Response to Submissions – SSD 6078

Oakdale Central – Horsley Park

Construction of Warehouse and Distribution Facilities - Lots 1C, 2B and 3

Section 75W Modification Application (MOD 3) – MP08_0065 - Oakdale Central, Horsley Park (Lot 21 in Deposited Plan 1173181)

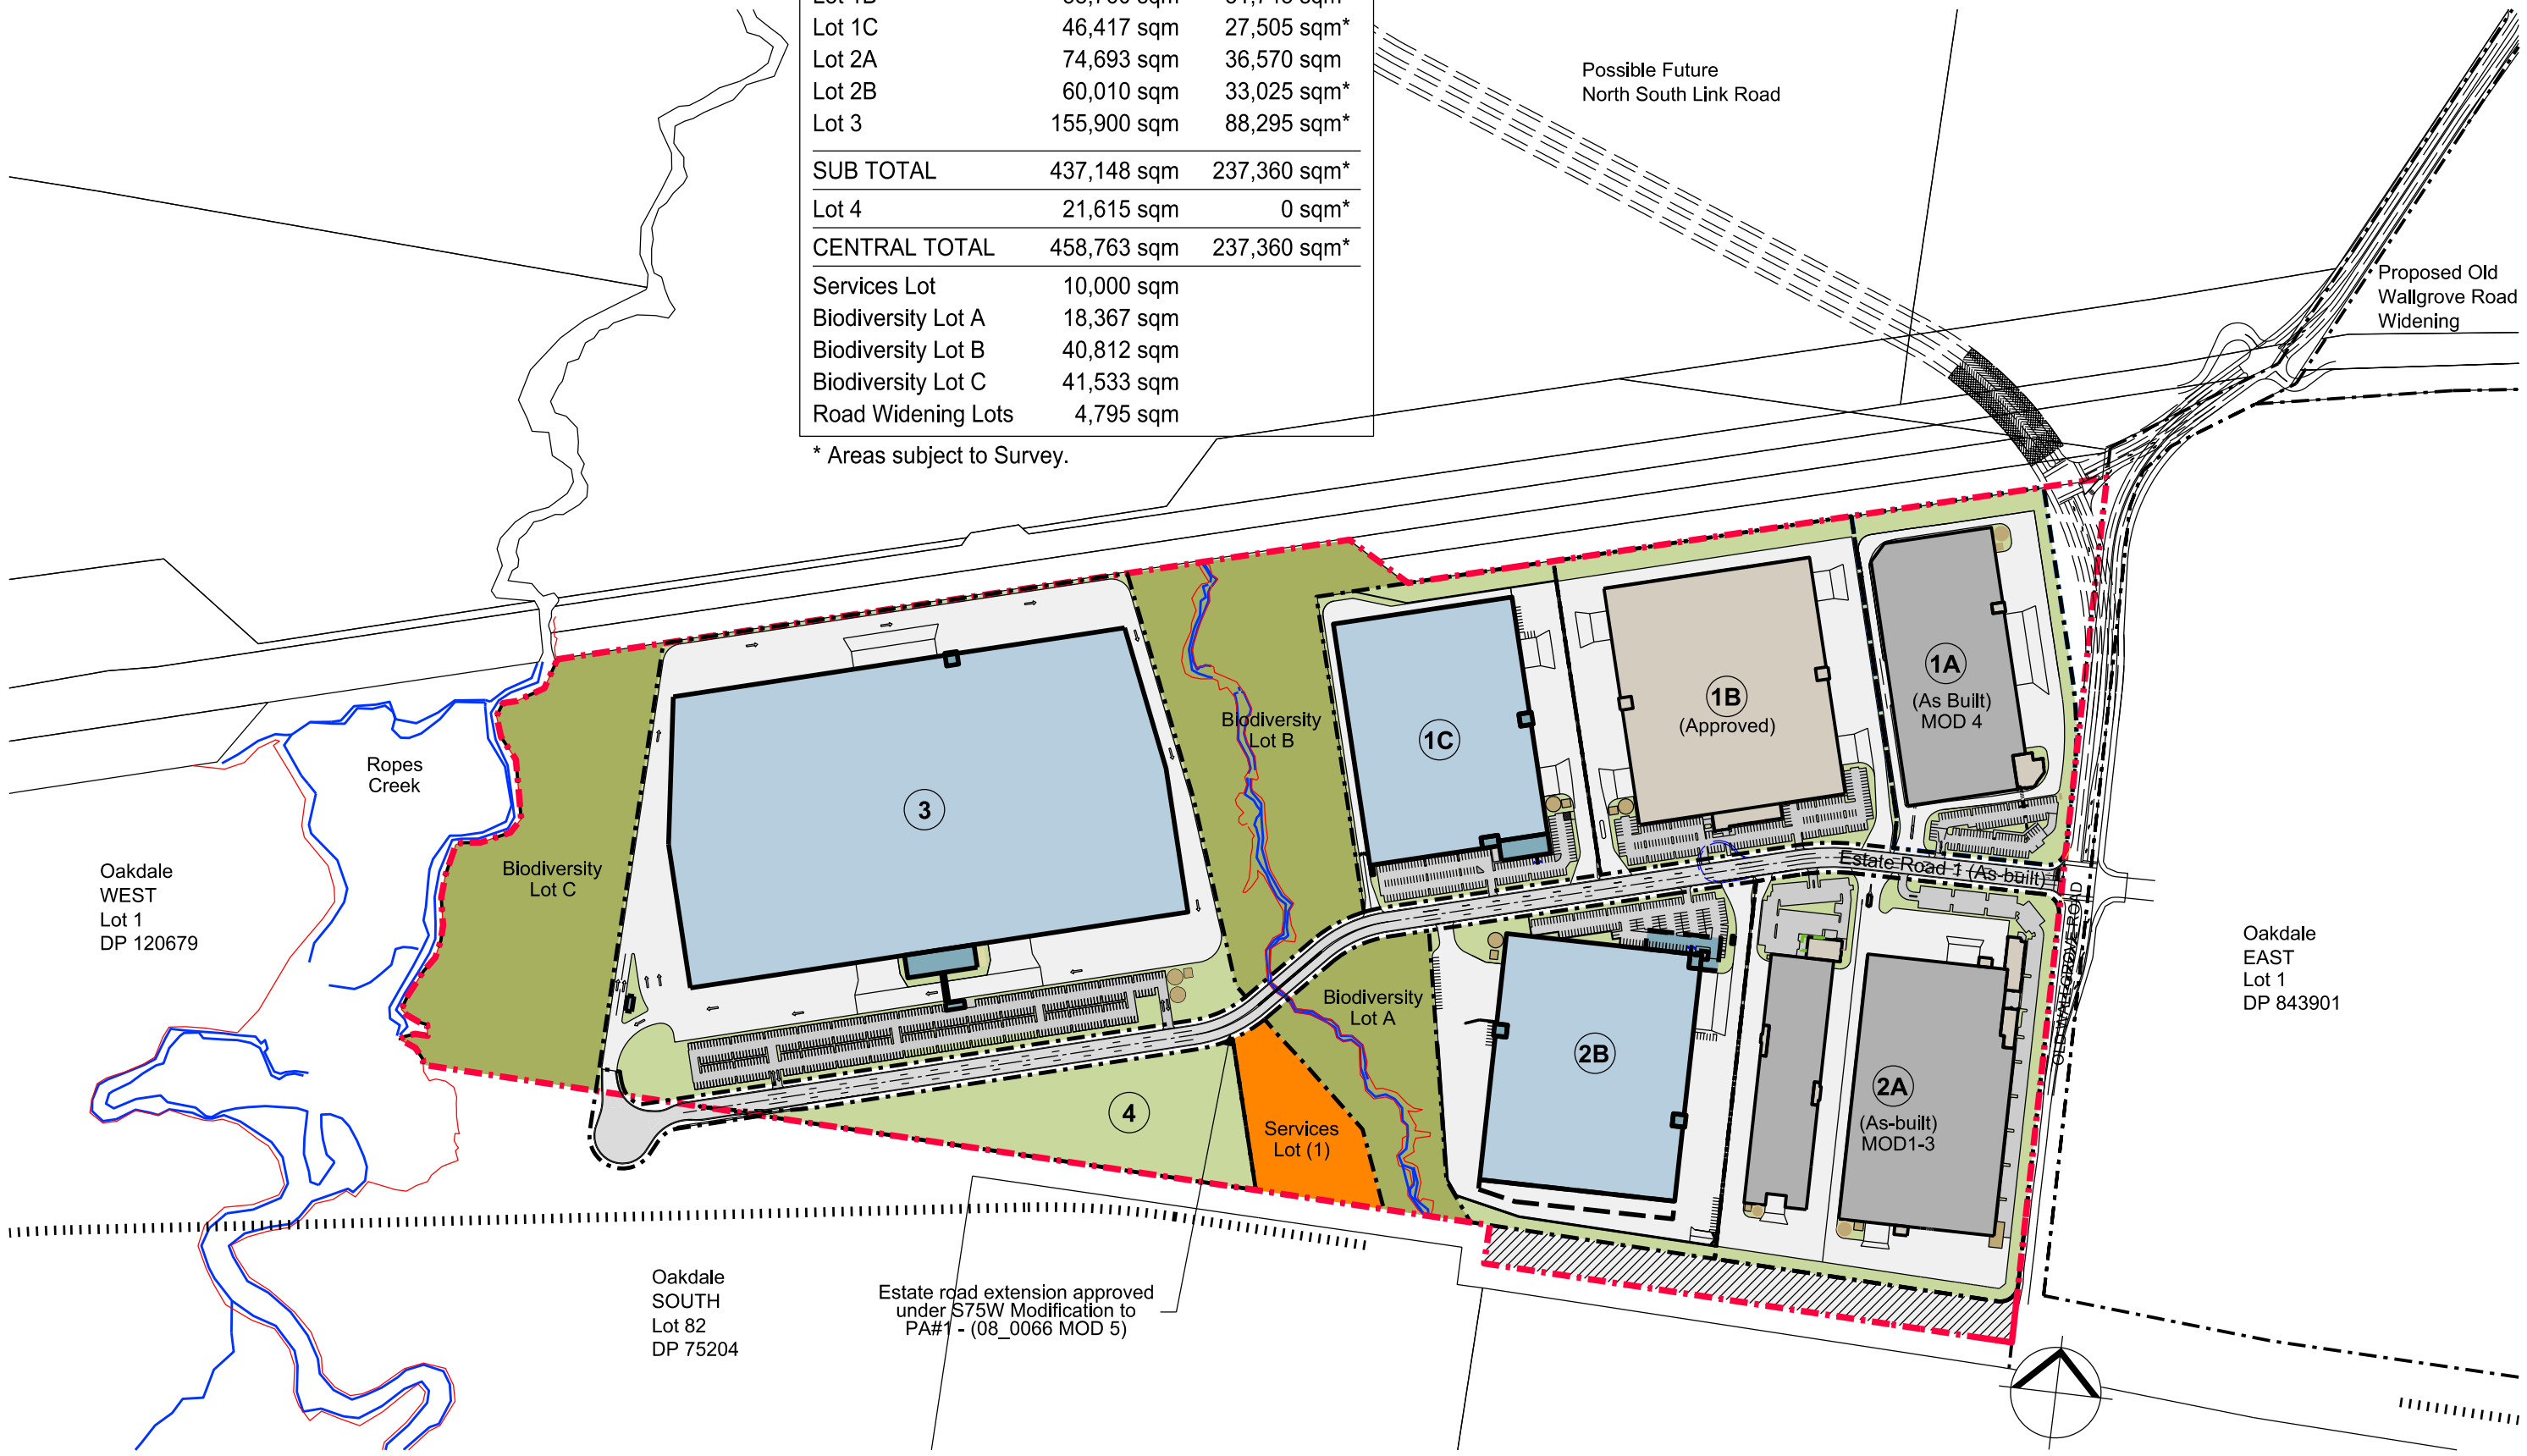
2. *A more detailed description and rationale is required for each of the proposed modifications to the "Estate Masterplan" (Plan No. OAK DA 02(K)) and "Subdivision Plan" (Plan No. OAK DA 04(A)).*

3. *With regards to the proposed amalgamation of Lots 3A and 3B into a single Lot 3, the following additional information is required:*

- *the "Subdivision Plan" is required to be amended by deleting the reference to Lots 3A and 3B, and replacing these with a reference to Lot 3 (including the total area of proposed Lot 3); and*
- *confirmation that the proposed boundary of the new amalgamated Lot 3 will remain the same as that of Lots 3A and 3B.*

Response: The proposed changes to the Estate Masterplan and Subdivision Plan are a result of the design of the facility proposed on Lot 3 and the provision of a turning head on the adjoining site being Lot 82 75204 (known as Oakdale South) which has been developed to accommodate the particular requirements of a customer. The particulars of the new scheme which impact on the estate layout are as follows:

Response: A revised Subdivision Plan has been prepared by SBA Architects and is annexed to this submission (see **Appendix 1**) which deletes reference to Lots 3A and 3B, amending the notation to "Lot 3" (plan reference **Subdivision Plan OAK DA 04 (B) 22 May 2014**). It is requested that this plan be referenced in Condition 1 under the General Terms of Approval.

The area of Lot 3 is proposed to remain unchanged from the Concept Approval with the resultant allotment size being 15.59 hectares. The alignment of Lot 3 will remain the same as was previously approved for Lots 3A and 3B and shall not encroach on the biodiversity lots.
